Case number: **PAX16.324258**

I wish to submit a formal objection to the proposed **Tirawley Wind Farm Strategic Infrastructure Development**.

Proposed Tirawley Wind Farm – Strategic Infrastructure Development Application

| Title | PROPOSED BATTERY STORAGE FACILITY COMPOUND ELEVATIONS - SECTION | | | | |

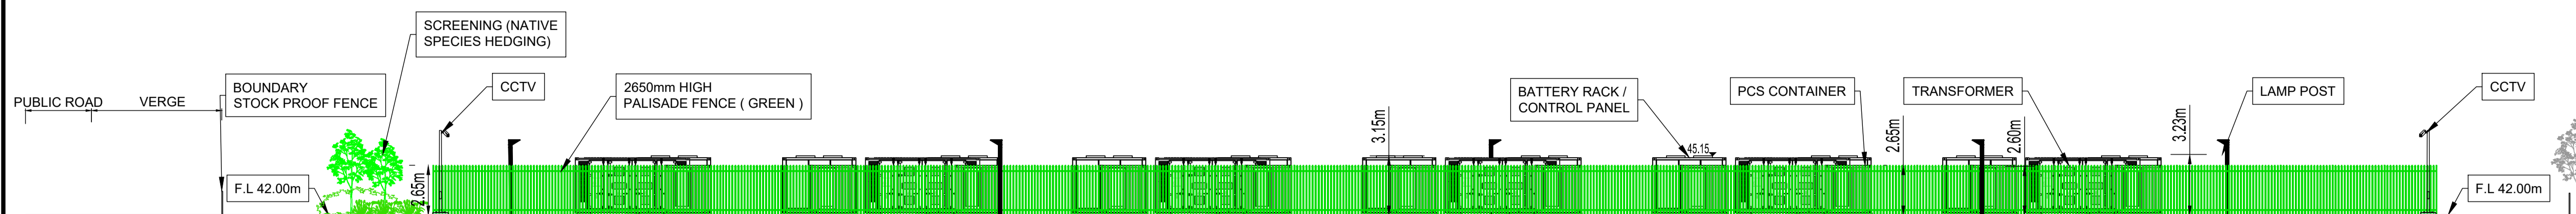
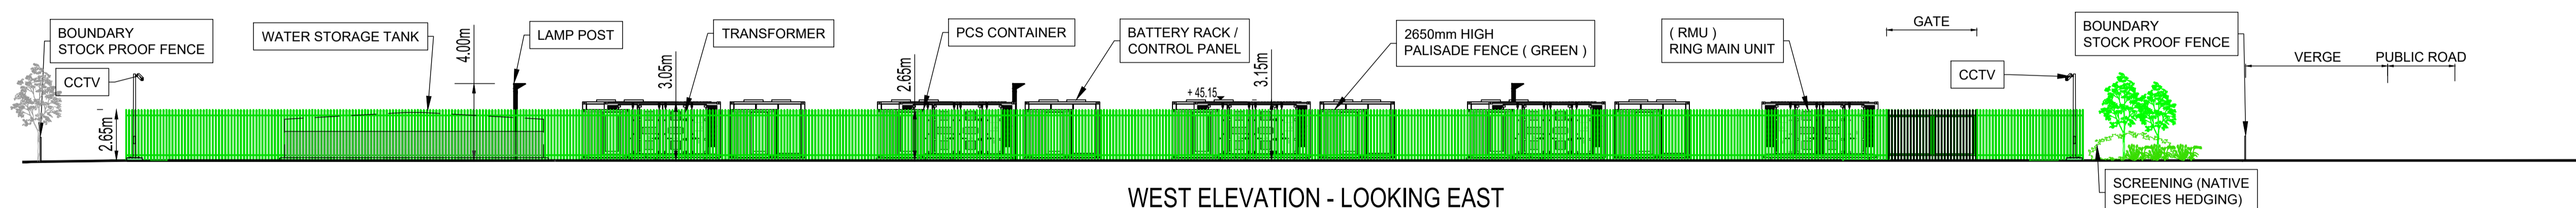
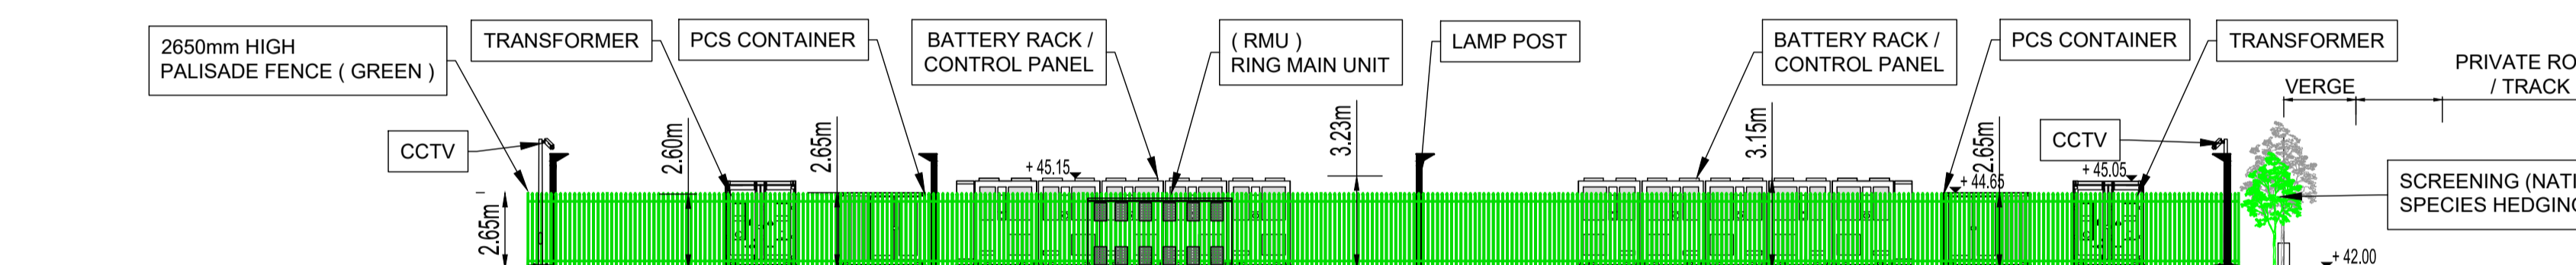
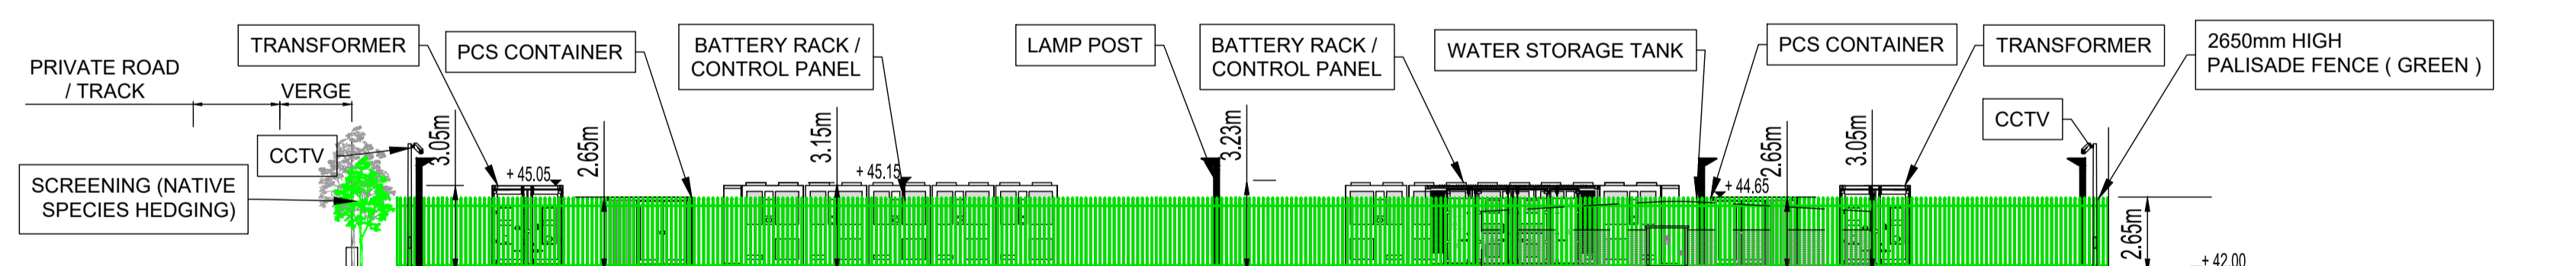
The application does not provide clear, enforceable separation distances between:

- Individual battery containers
- The BESS compound and the 110 kV substation
- The BESS compound and the public road
- The BESS compound and the nearest dwelling

International standards such as NFPA 855 and UL 9540A require minimum separation distances to limit fire spread, reduce explosion risk, and protect adjacent infrastructure and the public. The applicant has not demonstrated compliance with any recognised fire safety standard.

The application does not show:

- Turning circles for fire appliances
- Hardstand locations suitable for appliances and equipment
- Emergency access gates
- Clear, unobstructed access routes to the BESS compound

Plate 12.8: Zone of Theoretic Visibility Map (ZTV) based on bare-ground data showing the full extent of the 20km study area.

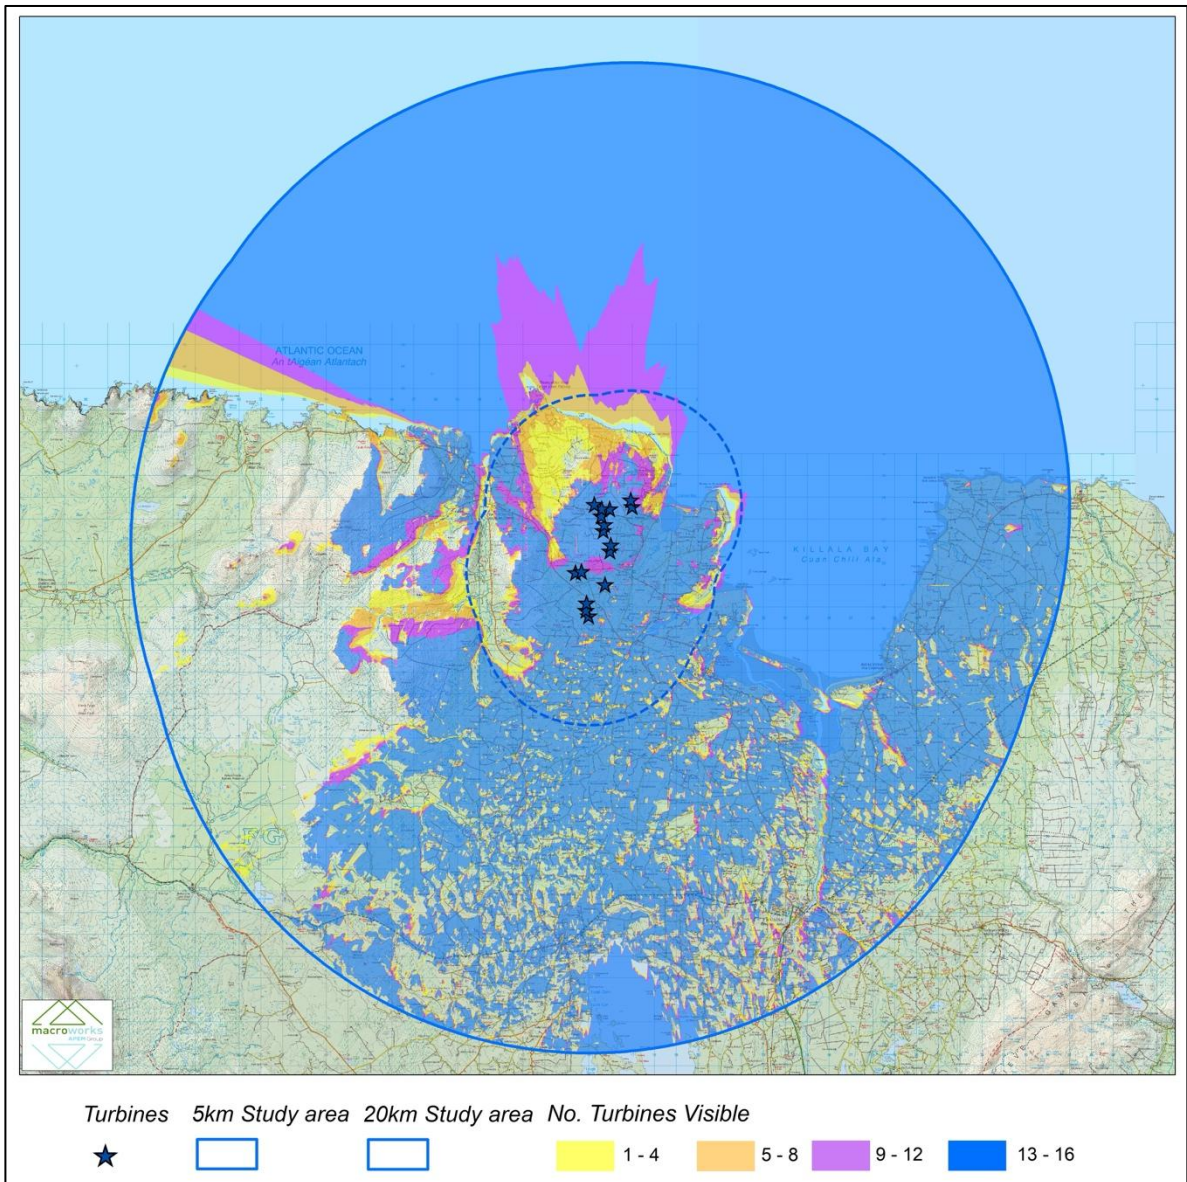
- Selective viewpoints
- Leaf-on photography
- Understated ZTV mapping
- Omission of key Wild Atlantic Way viewpoints

This misrepresents the true visual impact.

Plate 12.10: Cumulative ZTV Map (Tip Height -135m) for Tirawley Wind Farm identifying the potential intervisibility of the proposed Wind Farm and all other existing and consented wind farms within the study area (See Volume III Figure 12.10 for larger version).

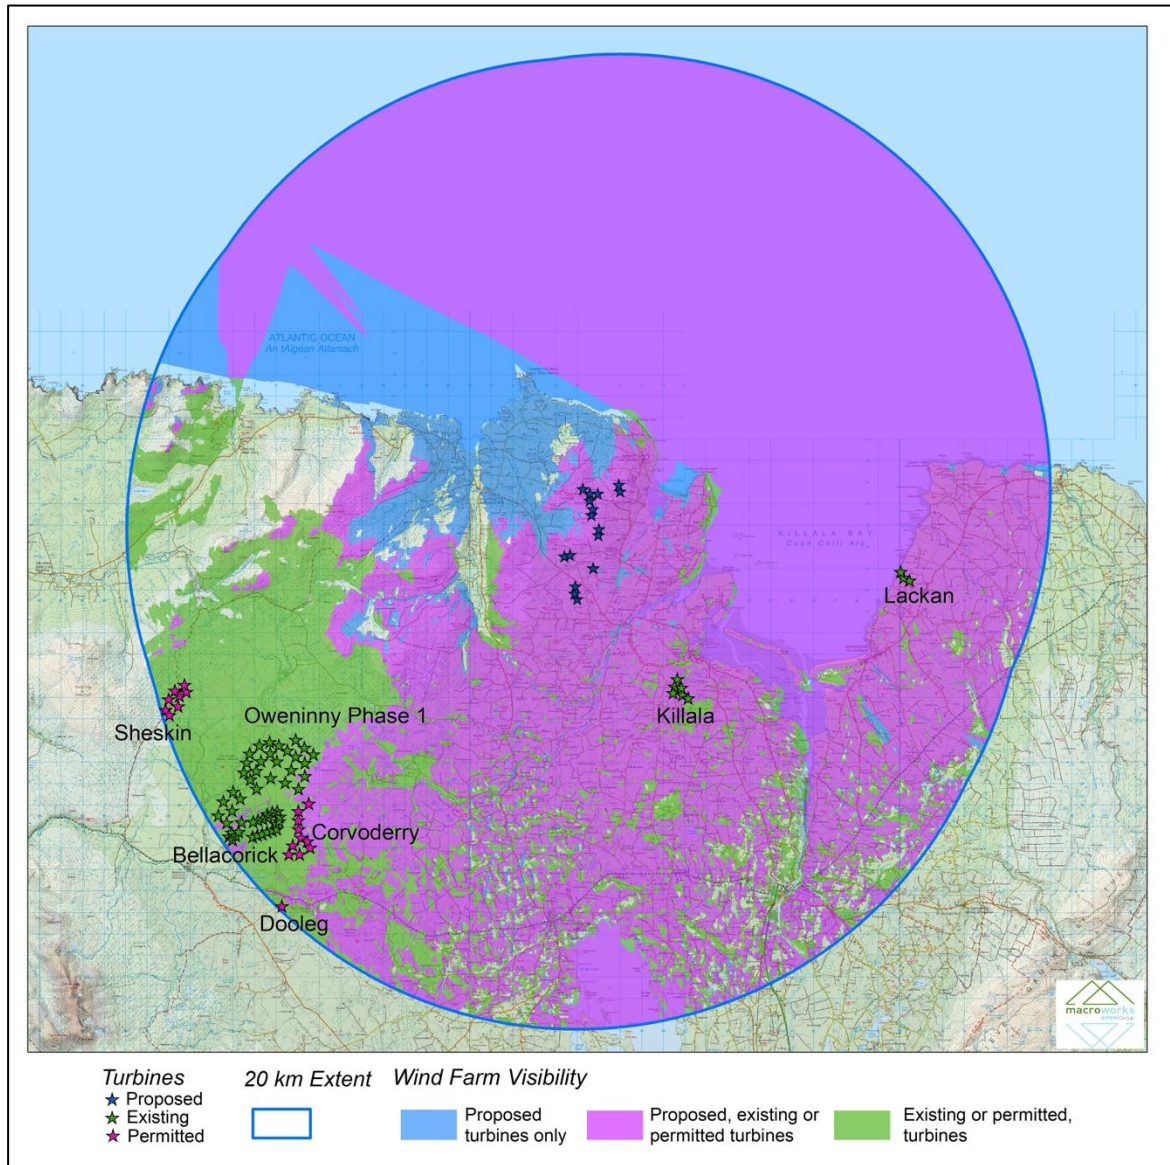
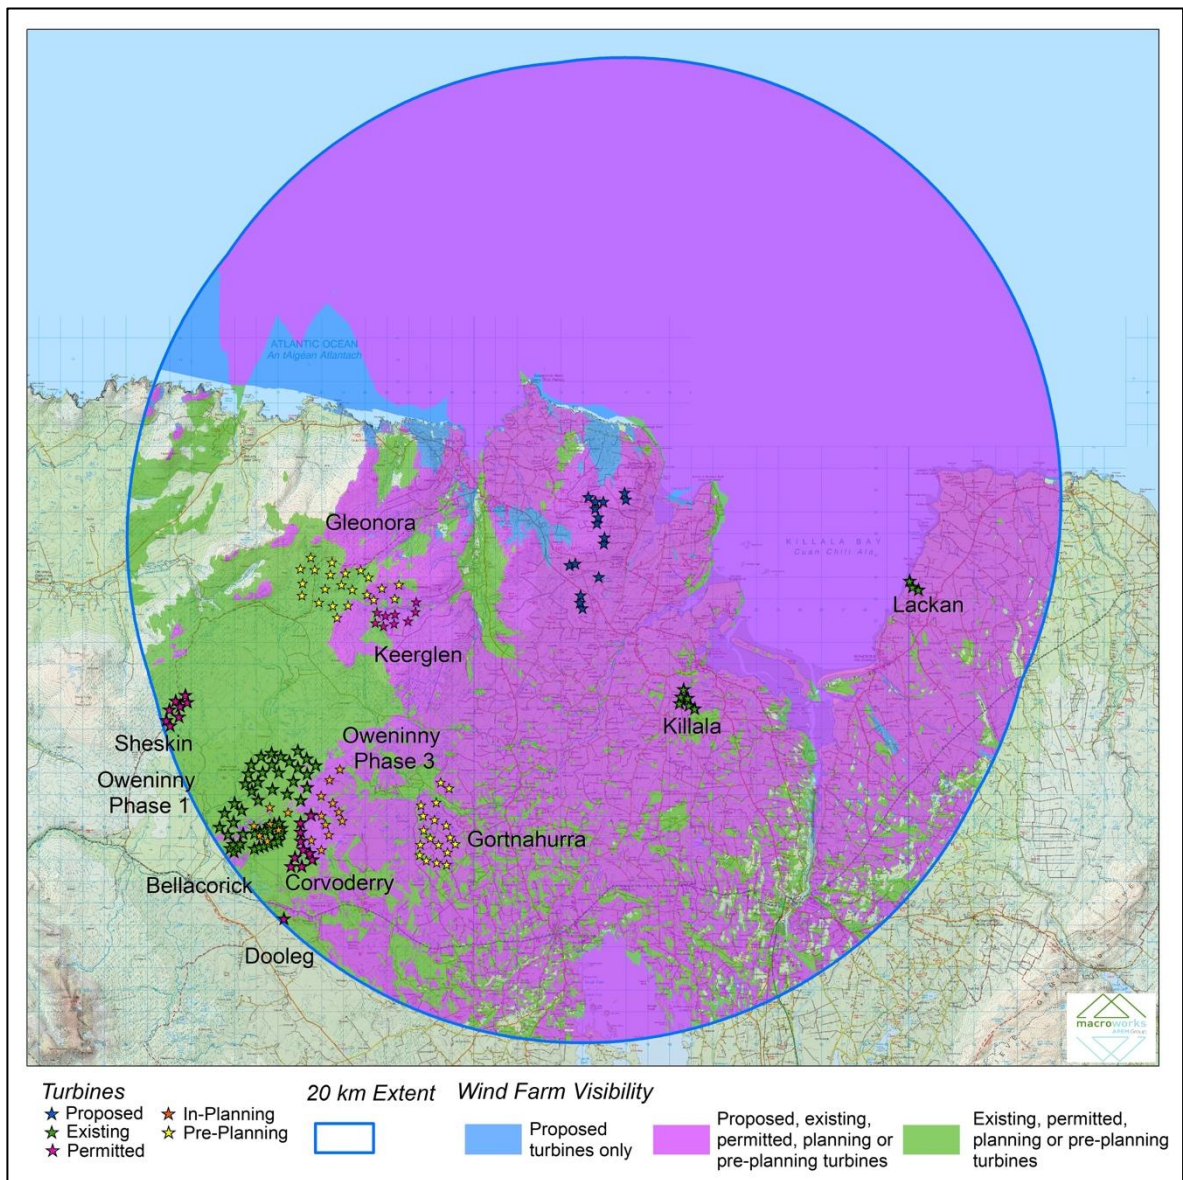
The EIAR fails to fully consider cumulative impacts with:

- Glenora (22 turbines, approved)
- Keerglen
- Clydagh (potential)
- Grid upgrades and 110 kV cable
